CITY OF ALBUQUERQUE

PLANNING DEPARTMENT – Development Review Services

**RE: Sevano Place Subdivision – Lots 13-20 Block 29, N. Albq. Acres
Drainage Report
Engineer's Stamp Date 5-14-2014 (File: C18D075)**

Based upon the information provided in your submittal received 6-04-14, the above referenced Drainage Report cannot be approved for Preliminary Plat and Site Plan for Subdivision for DRB action until the following comments are addressed:

Sheet: THE MASTER GRADING AND DRAINAGE PLAN

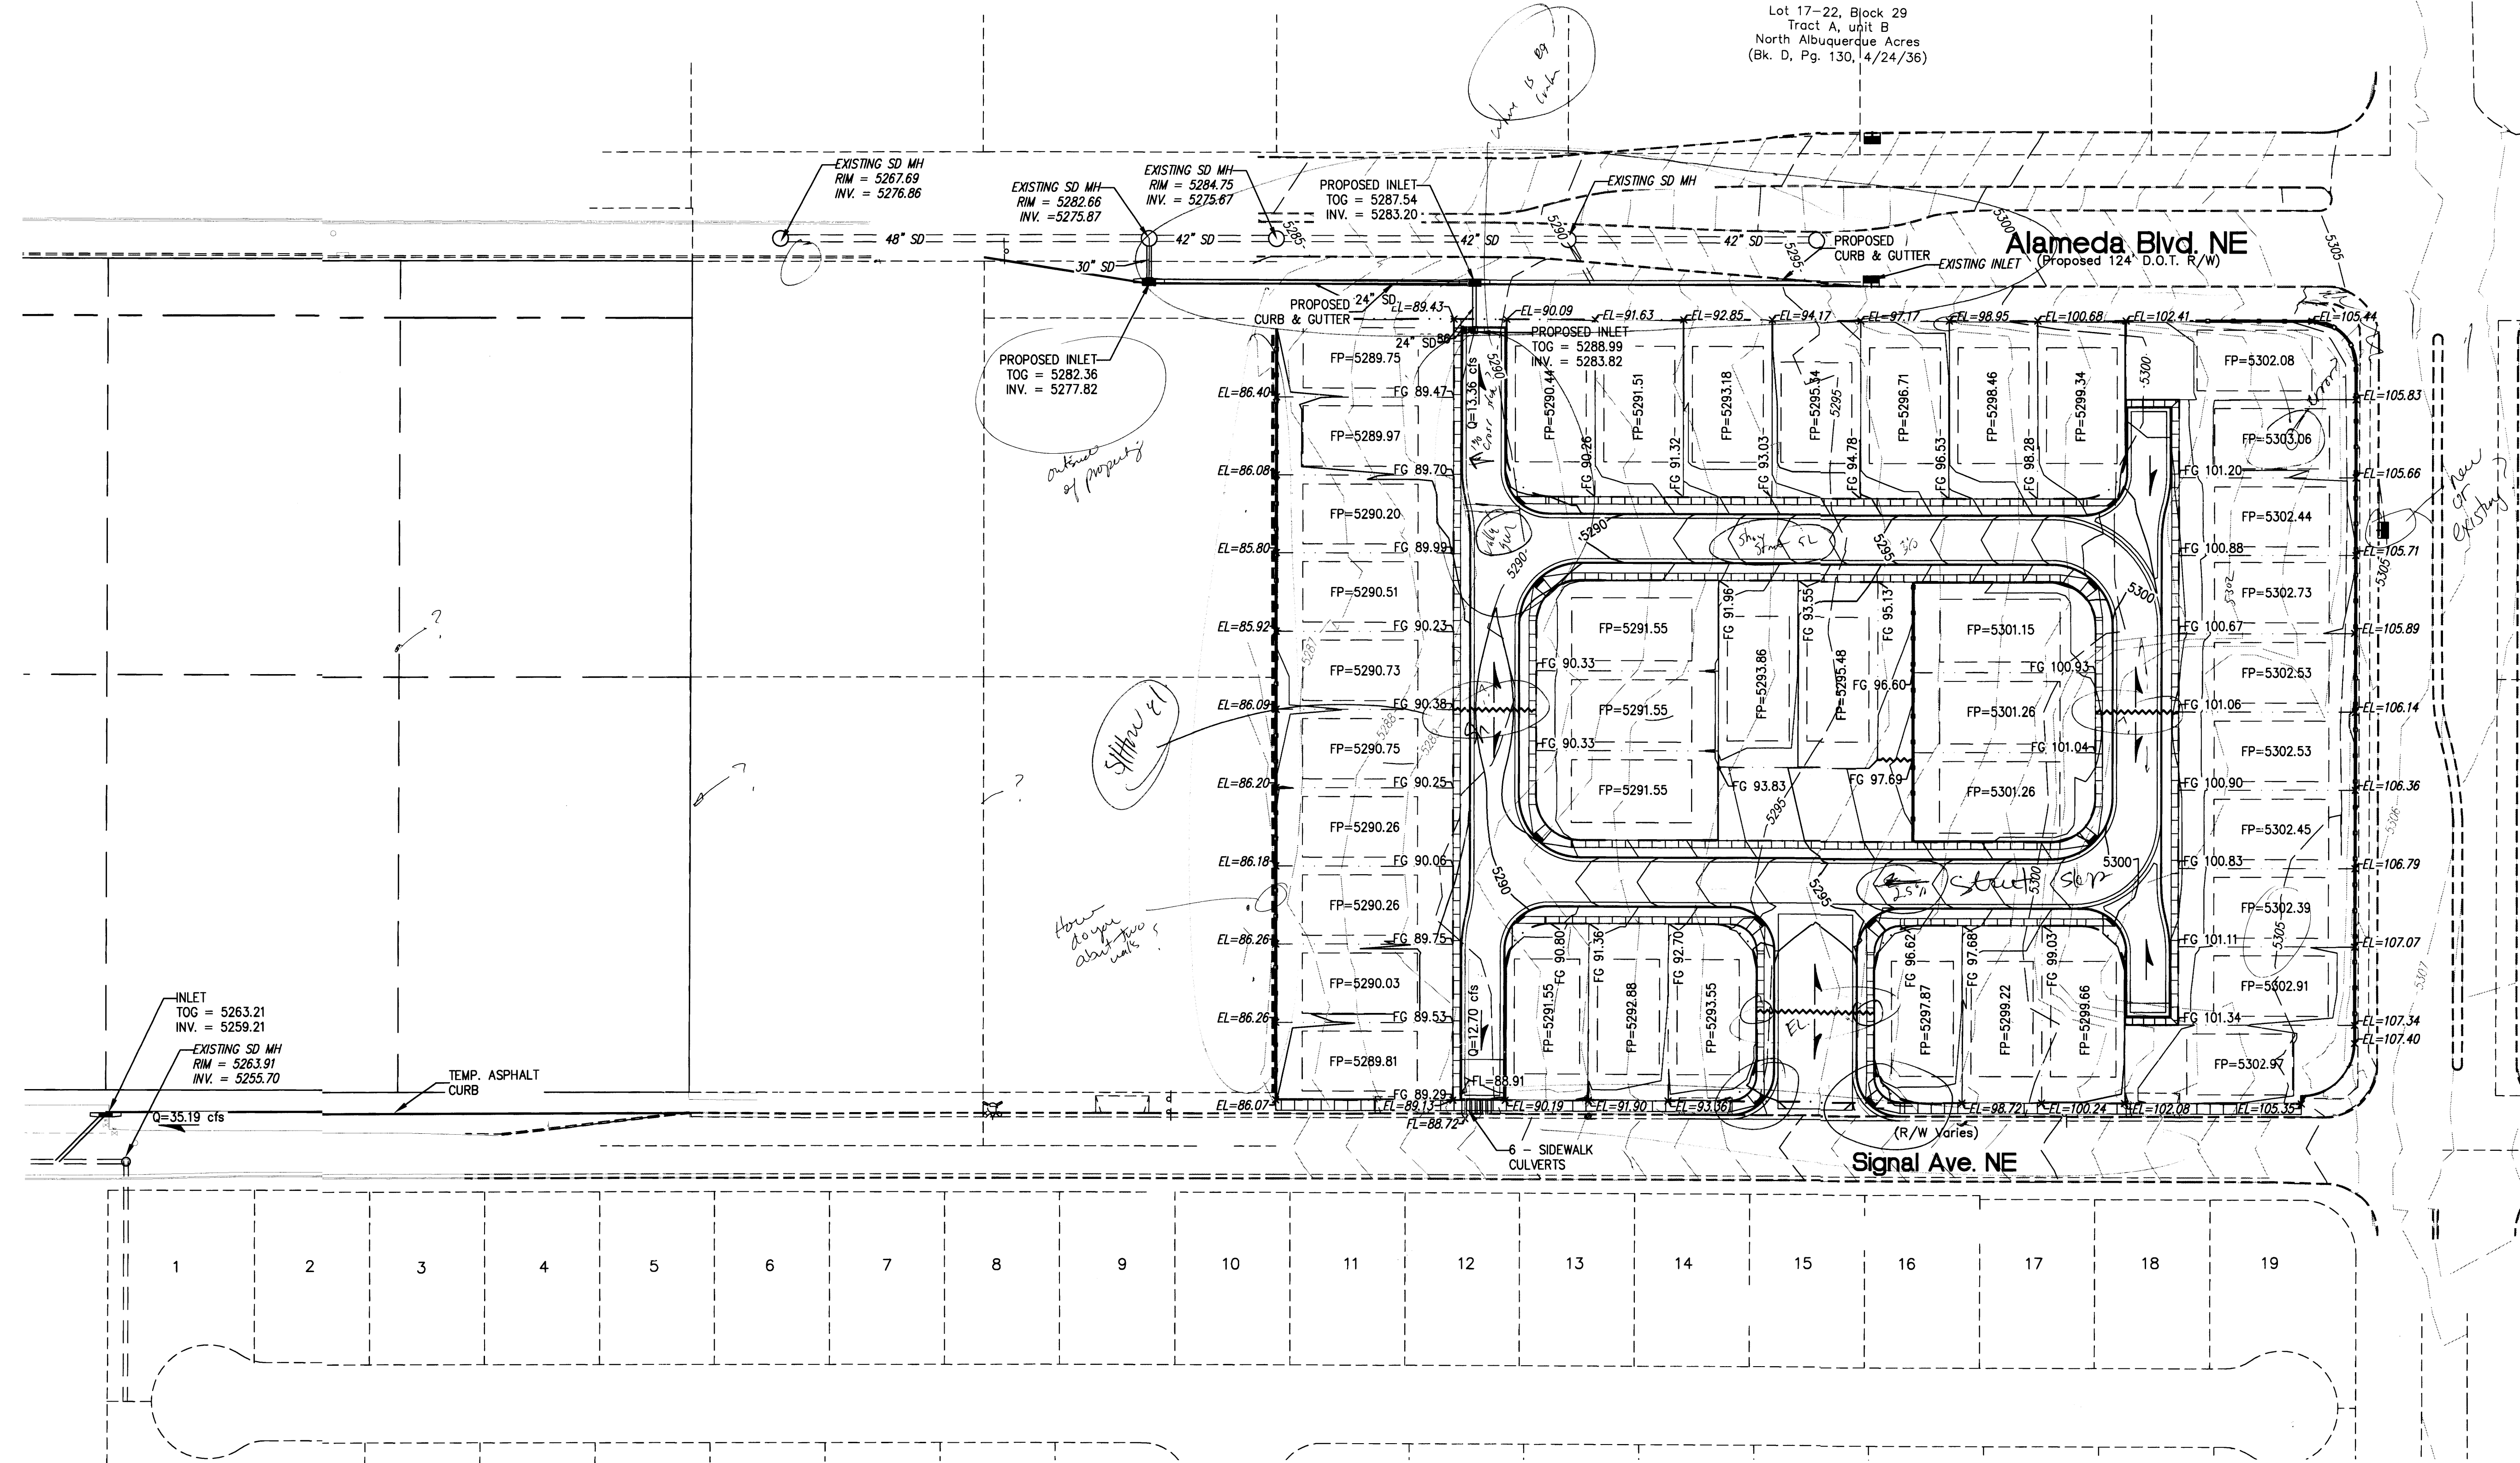
- 3) Show street slopes on Grading Plan.
- 4) Show elevations at waterstops and grade breaks, and flowline elevations at curb returns and valley gutters.

- 5) Stub street running N-S on west side of subdivision appears to be flat and grade break is across the 5290' contour. Do flows from streets running E-W cross the stub street via valley gutters? How are flows directed towards inlet on N. end and sidewalk culverts on S. end?

- 6) Show Benchmark and Survey information
- 7) Show curb lines, curb and gutter, Top of Curb and Flowline Elevations.
- 8) For retaining walls, show Top of Wall and Bottom of wall elevations. Show FG elevations and contours on adjacent property.

- 9) The curb and gutter does not seem to be well defined around the north and east sides of subdivision.
- 10) Show property line and ROW, and any easements.

- 11) Since inlets are proposed beyond property line, show existing conditions and proposed construction.
- 12) Pages 6, 11, 12 and 14 of Drainage report are difficult to read (inv. Elevations)
